**West Yorkshire Police
Kirklees District**

To: Chris Carroll	Ref: 2019/92587 Date: 30 th August 2019
-------------------	---

Site Location: Wheelwright Centre, Birkdale Road, Dewsbury, WF13 4HG

Application Type: Conversion of building to form 65 residential units

PROPOSED SITE LAYOUT

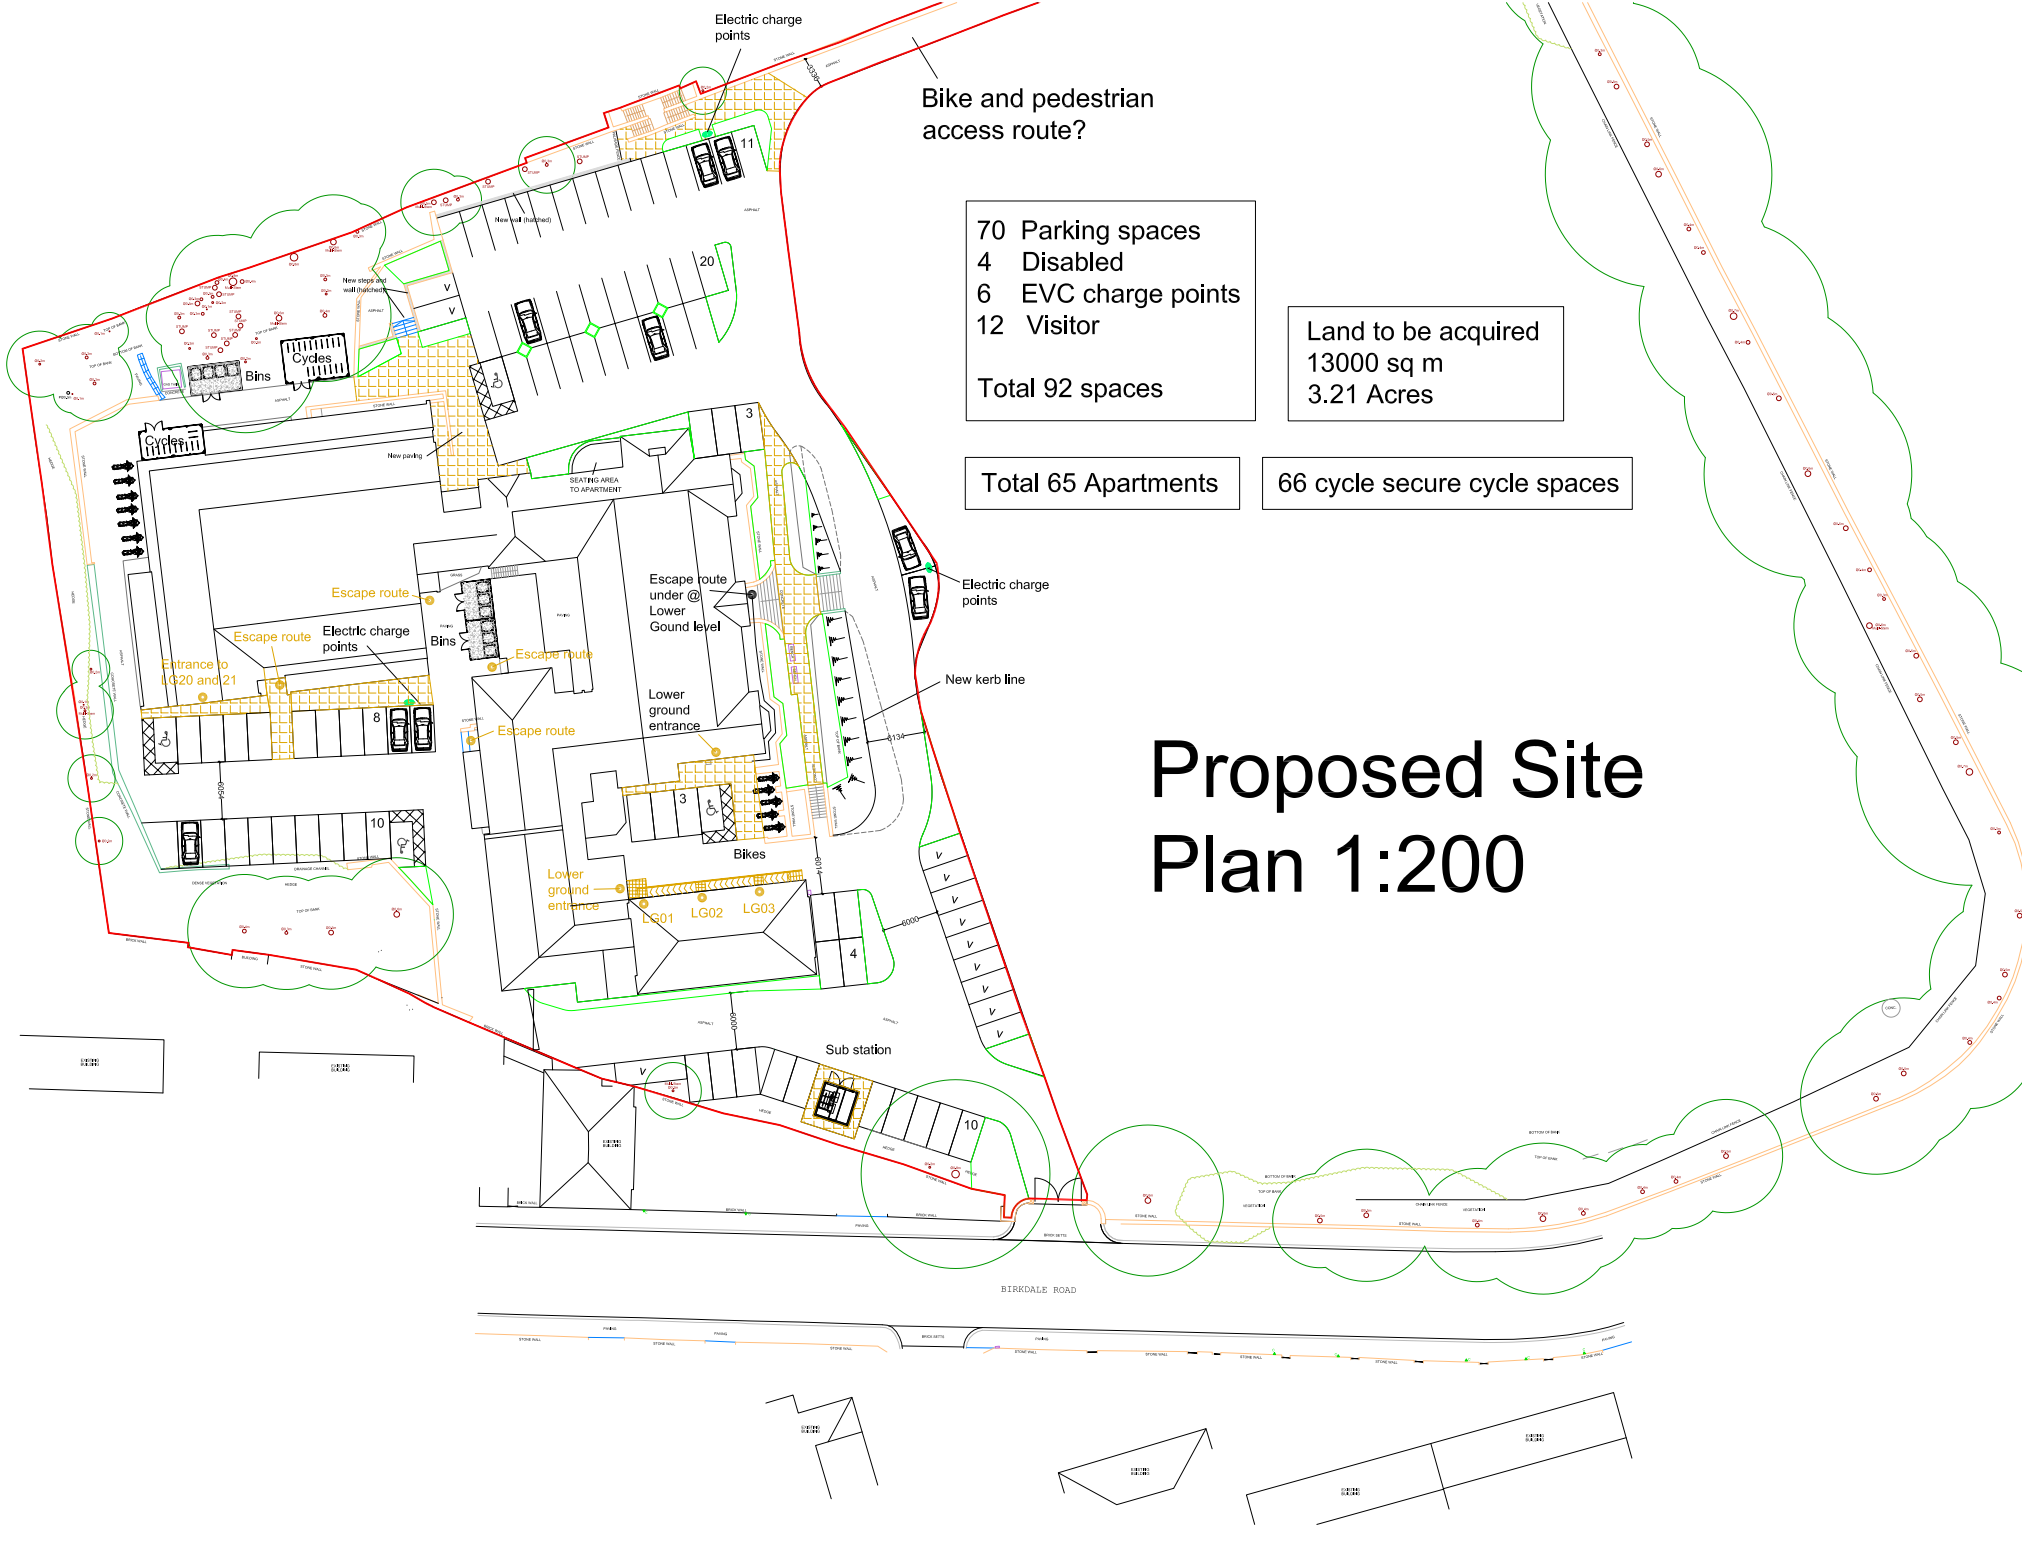
It is recommended the rear boundary to the North of the site backing on to the open space has additional treatment on top of the existing stone wall. I would suggest installing close link welded mesh or expanding metal fencing to a height of at least 1.8m. This should be installed on top of the stone wall as close to the external facing edge as possible to prevent footholds for climbing. The fencing must secure the West corner of the site and should extend beyond the stone steps on the North boundary to cut off access from the field onto the North car park of the site.

The current siting of the cycle bays are of concern, especially the one on the North boundary. I welcome the comments about bringing the cycle storage into the building. This will add to the overall security. PAS24 2016 doors will be required to be fitted to the entrance of the cycle store.

Parking provision should be within view of the car owner's home. Rear parking court areas that are hidden from view are unacceptable. They are known to become associated with nuisance and anti-social behaviour as well as increasing the opportunity for car crime and rear access burglary. It would be advisable to have restricted access to rear parking areas with some kind of access control system in place, such as a rise and fall barrier for example.
